Date: 22 November 2019

Application by ScottishPower Renewables for an Order Granting Development Consent for the East Anglia TWO Offshore Wind Farm

Advice following issue of decision to accept the application for examination

East Anglia TWO Offshore Wind Farm

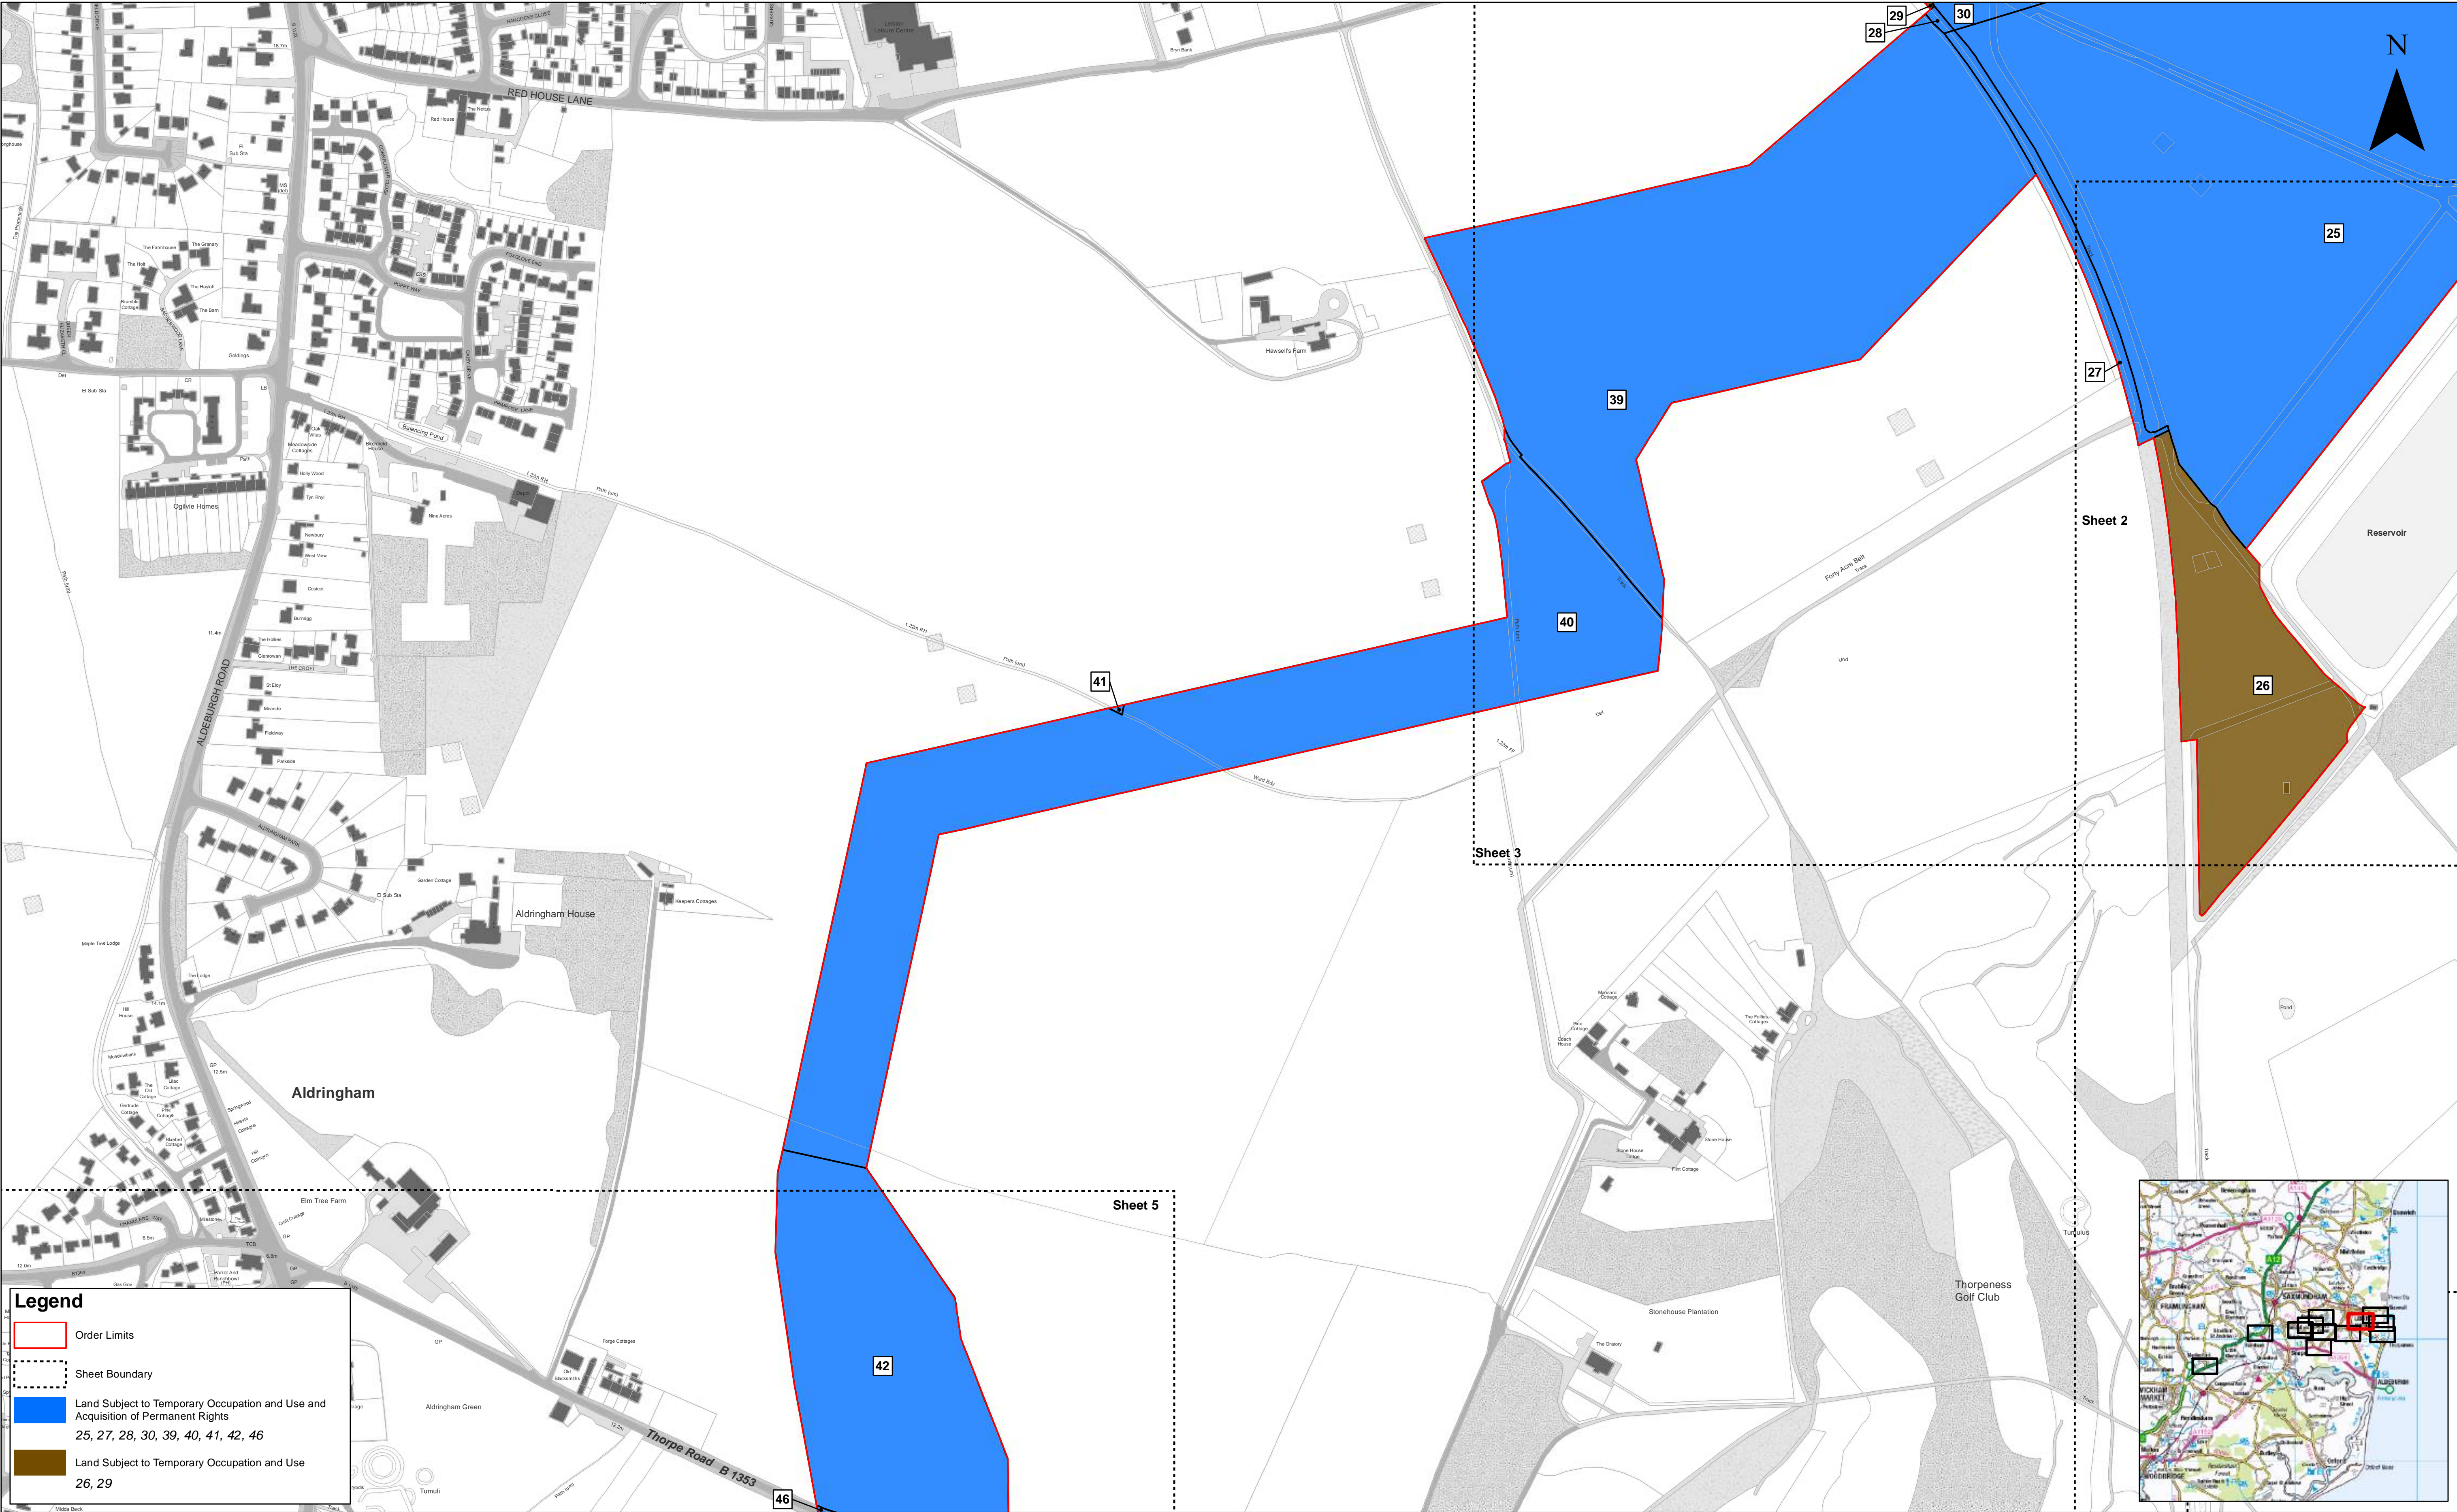
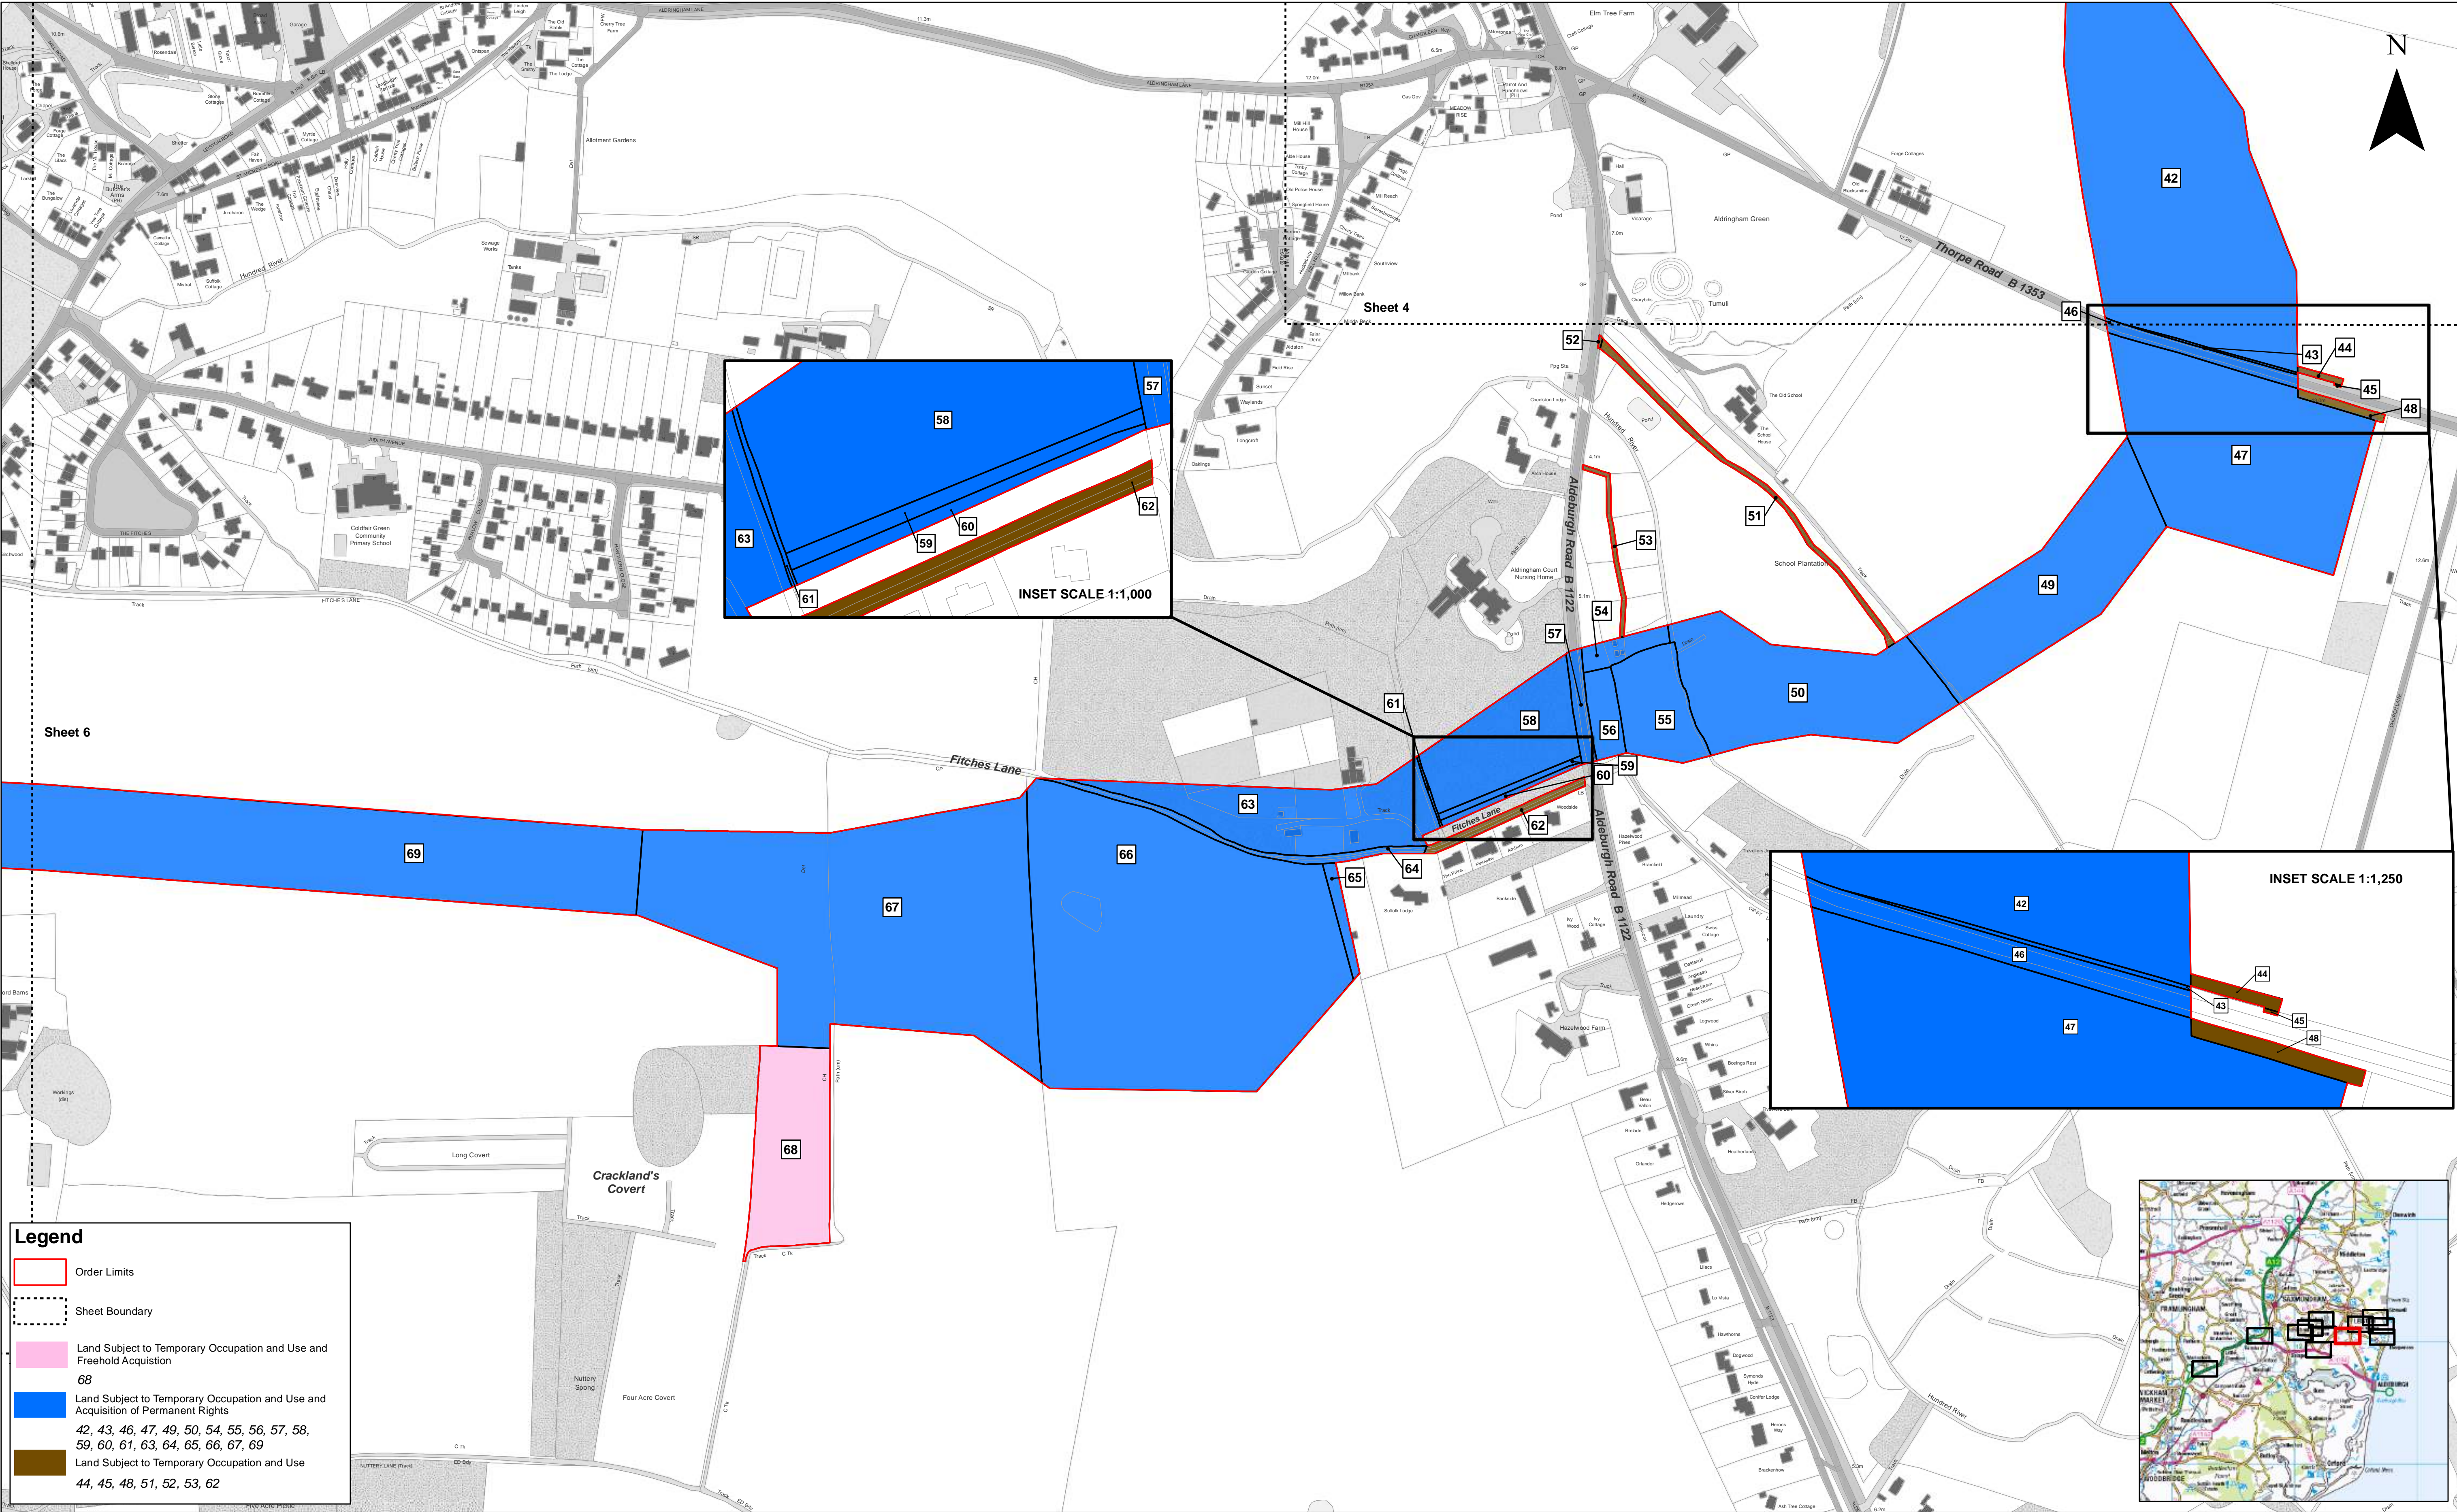
Please provide updated Land Plans which include:

- The names of all relevant landmarks described in Column 2 ('Extent of acquisition or use') of the BoR (e.g. Sizewell Estate, Sizewell Gap, Grimsey's Lane, Blackheath Estate, Redhouse Farm and Knodishall Hall) should also be shown on the relevant Sheets of the Land Plans.

- Road names on the Land Plans to assist the identification of land should be shown more clearly.
- Larger and clearer landmarks on the relevant Sheets of the Land Plans.

- The same map base as the other submitted plans and sheet layout. (It was noted in the checklist that the Land Plans have used a different map base to the other submitted plans, and this makes comparison between the Land Plans and the other submitted plans more difficult than it needs to be.)

- Additional insets. (It was noted in the checklist that Plots 18, 91 and 126 would benefit from being shown on an inset plan.)
- Corrected Plot number for inset 9.4.
